CITY OF ALBUQUERQUE

February 6, 2015

**Re: Smiles for Kids Dental Office
Conceptual DMP and Conceptual Grading Plan
Engineer's Stamp Date -no stamp- (C12D054)**

sheet
C101

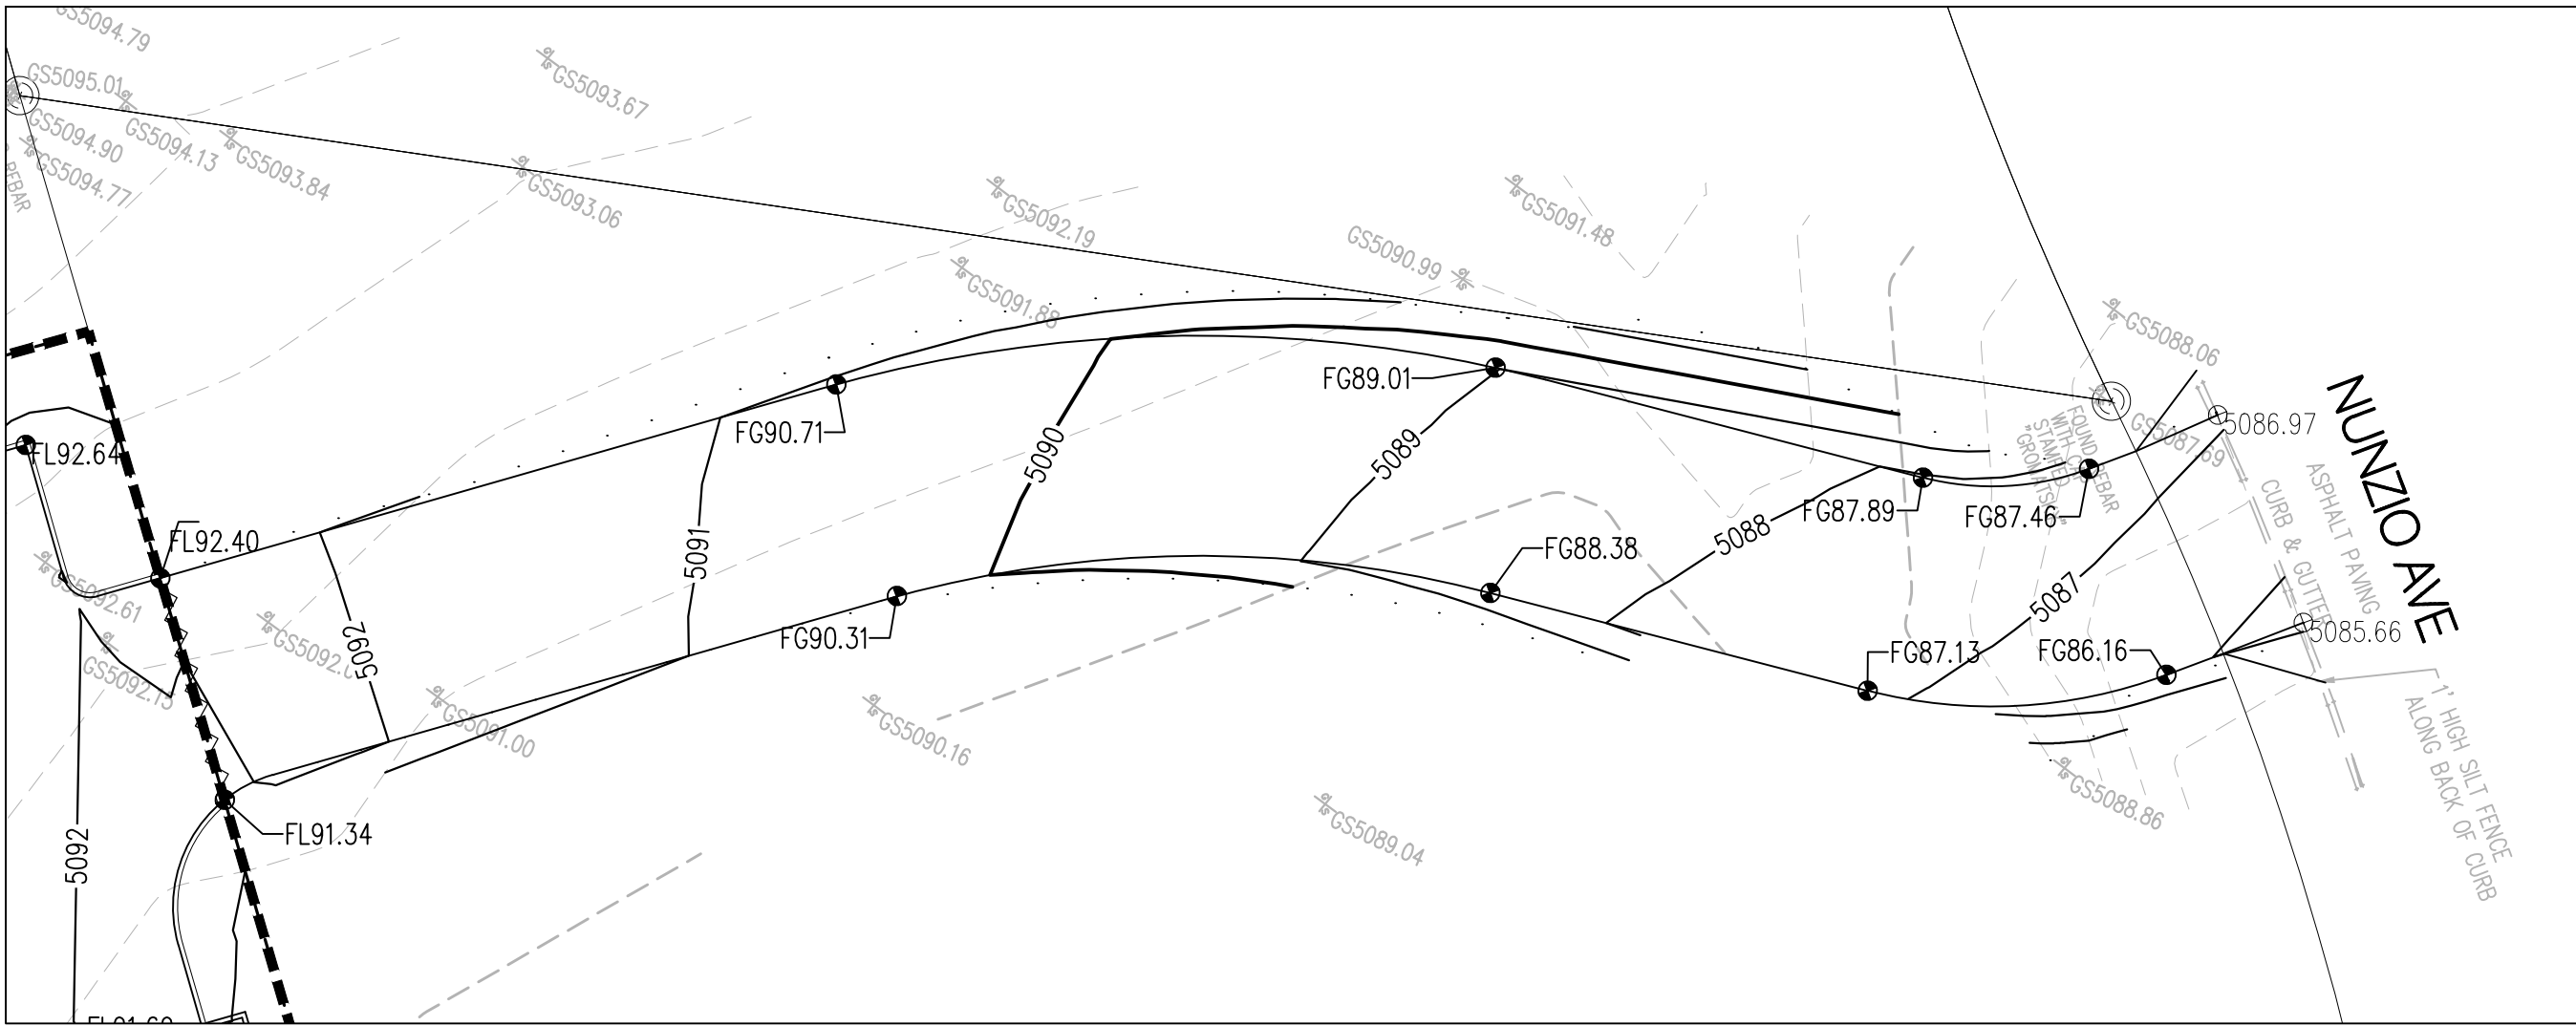
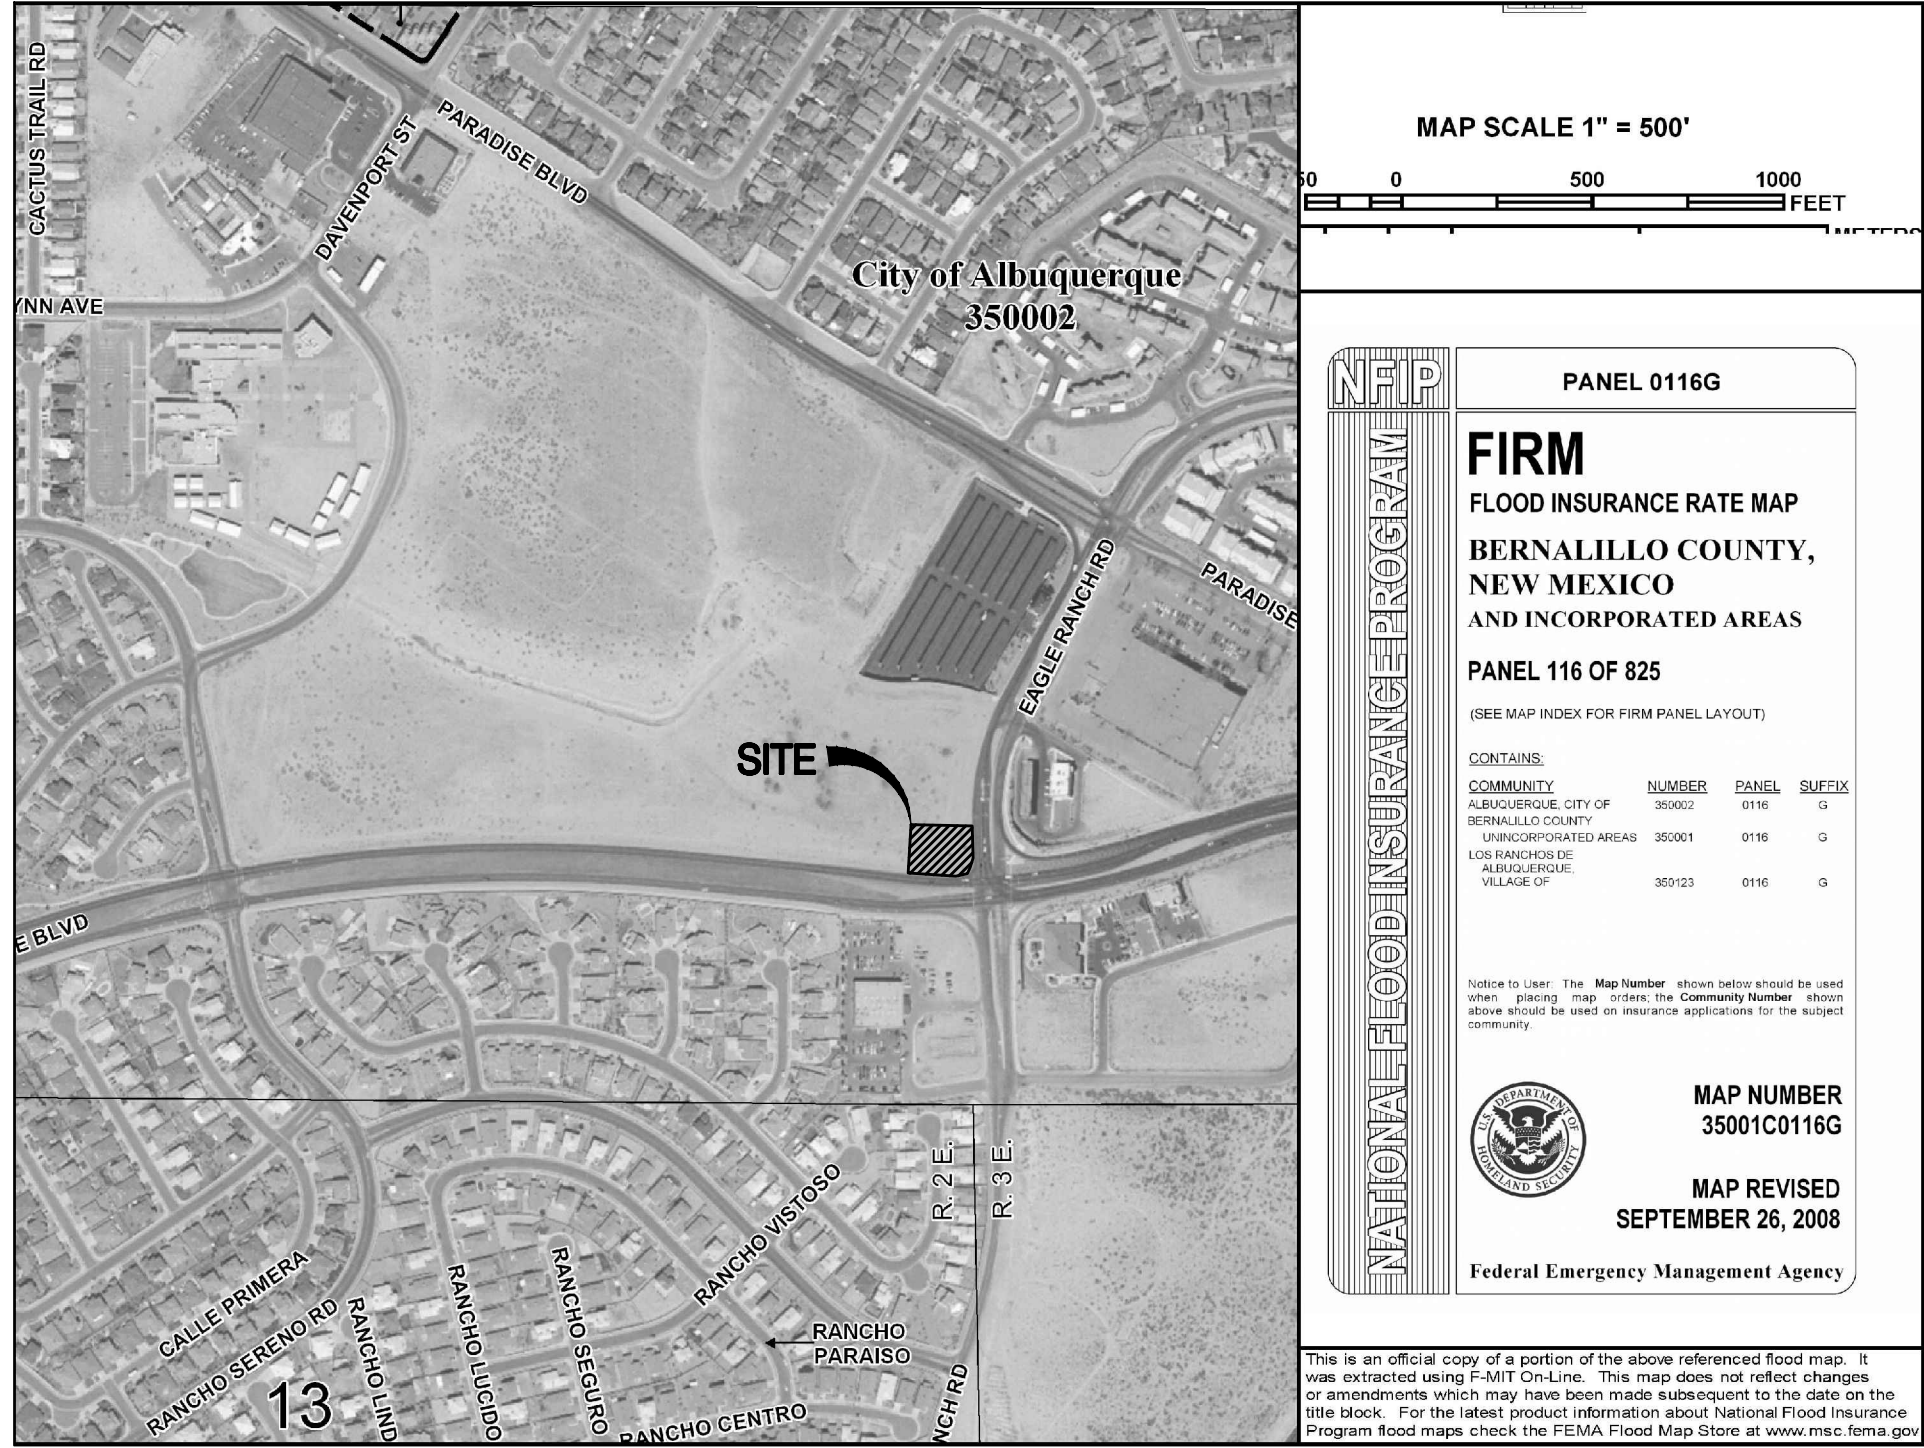
1. The plan discusses and shows first flush ponding areas, however, they don't appear to accept any flows from impervious areas. Per our discussion, first flush ponds should be relocated to the parking lot, transverse to the parking spaces in the middle of the lot (similar to Fidelity at MDS), and to the upstream portion of the ribbon channel.

Provide a calculation for the first flush volume and where this volume will be retained. As previously discussed, the steepness of this site may provide justification for providing less than the required first flush volume per the ordinance.
